Rezoning Transportation Analysis

Petition Number: 2020-138

General Location Identifier: Tax ID (08705510)

Date	Description
10-23-20	First Review (EL)
11-30-20	Second Review (EL)

SITE PLAN

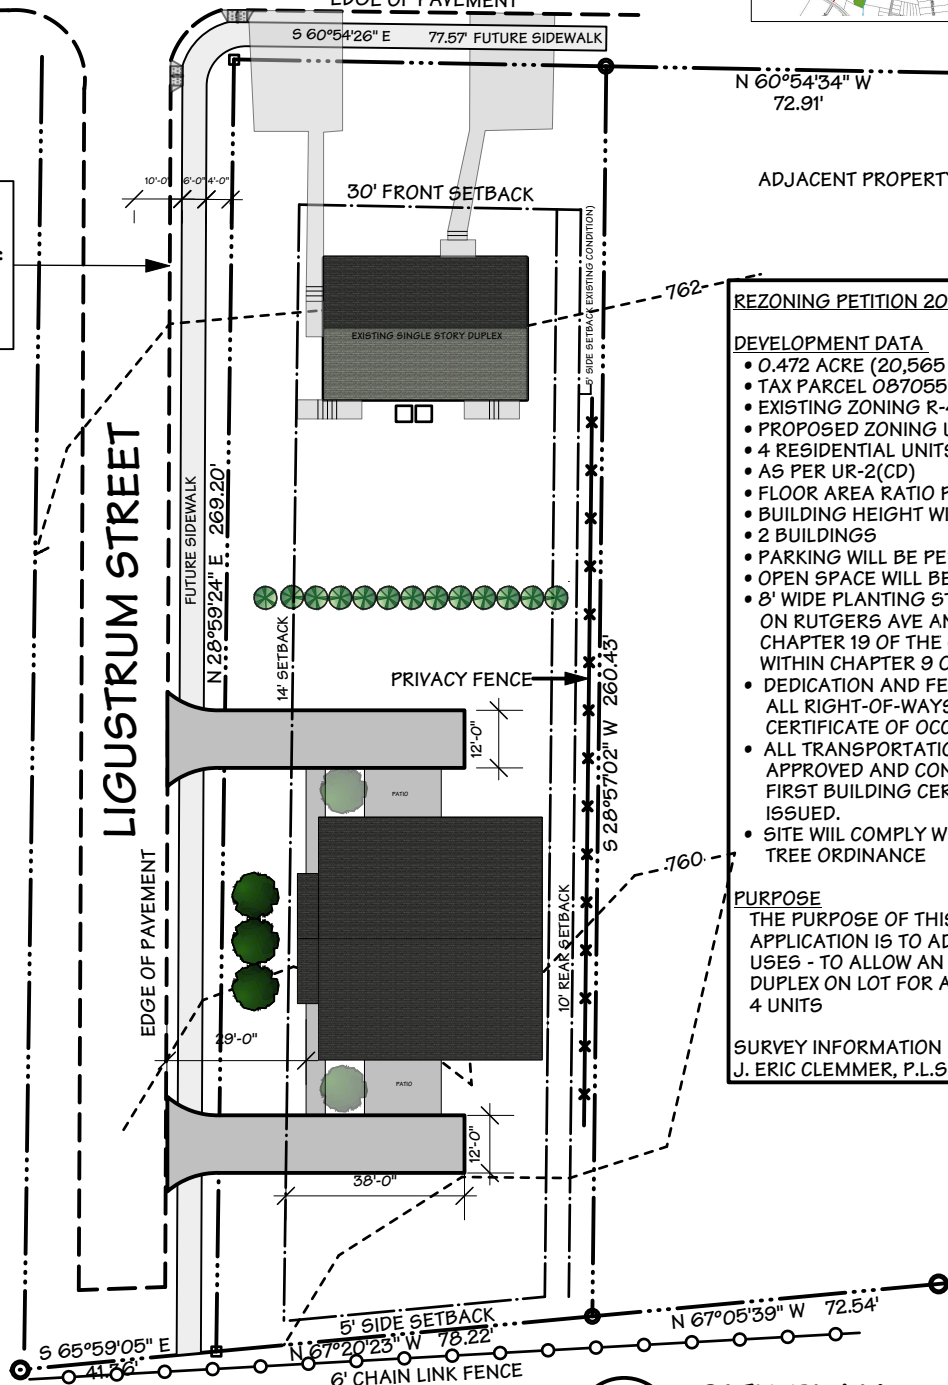
Label and dimension curb and gutter from the centerline for each road on the site plan.

- Outstanding (site plan dated 11.16.2020)** Revise site plan and conditional note(s) to commit to construct an 8-foot planting strip, and 6-foot sidewalk on Rutgers Avenue and Ligustrum Street, per Chapter 19 of the City Code and required within Chapter 9 of the Zoning Ordinance. Label and dimension both items from the back of curb and gutter and road centerline on the site plan.

- Outstanding (site plan dated 11.16.2020)** Add site plan note(s) specifying dedication and fee simple conveyance of all rights-of-way to the City before the site's first building certificate of occupancy is issued. CDOT requests rights-of-way set at 2' behind back of sidewalk where feasible.

- Outstanding (site plan dated 11.16.2020)** Add site plan note specifying that all transportation improvements will be approved and constructed before the site's first building certificate of occupancy is issued. The petitioner may phase transportation improvements if said improvements and phasing are explicitly described in site plan notes.

- New Comment (site plan dated 11.16.2020)** Revise site plan and conditional note(s) to commit to providing two accessible ramps at the intersection corner of Rutgers Avenue and Ligustrum Street.
